Subject: 5542 L.P UoC Upper Bognor Road residential redevelopment RE BR/351/19/PL new building eaves

Drawing no.
5542-006-D1

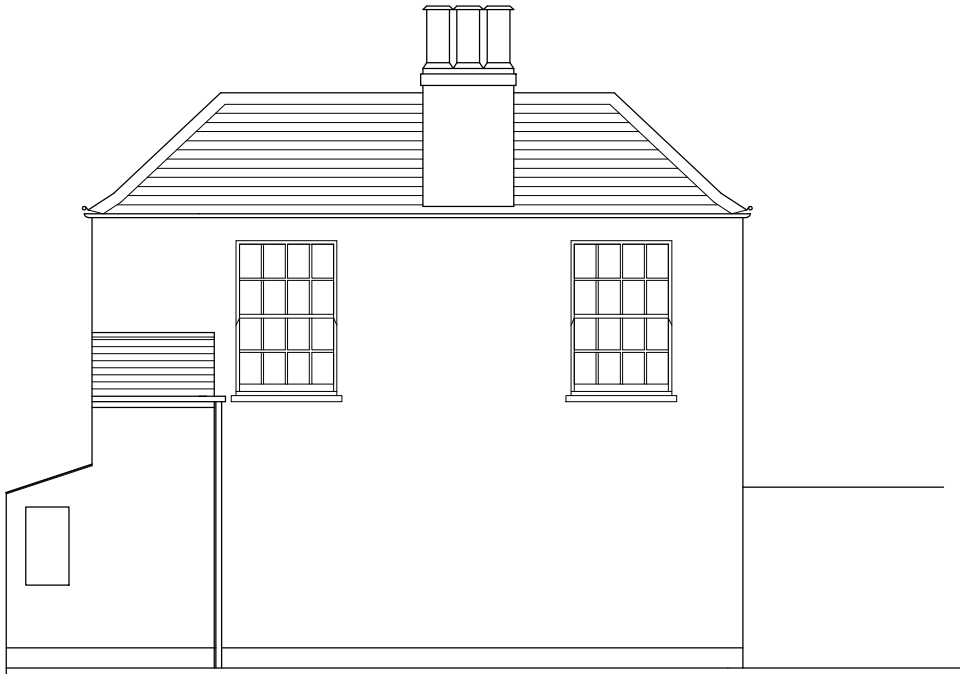
With regard to the eaves to the new building, the intention was to reflect the eaves detail of 67 & 69 and 71 Upper Bognor Road which basically have no overhang and so no eaves as such, the eaves gutter being fixed directly in front of the building façade (see the attached photos). To have an overhanging eaves would be out of keeping and we were concerned that the new building may also then start to compete architecturally with 71 Upper Bognor Road when the aim was always for the new building to be treated like an outbuilding, subservient to the focal listed building (no 71). We would hope that this could then be treated as a condition with a suitable form of words as detail design will be the responsibility of the developer to whom the land is sold.
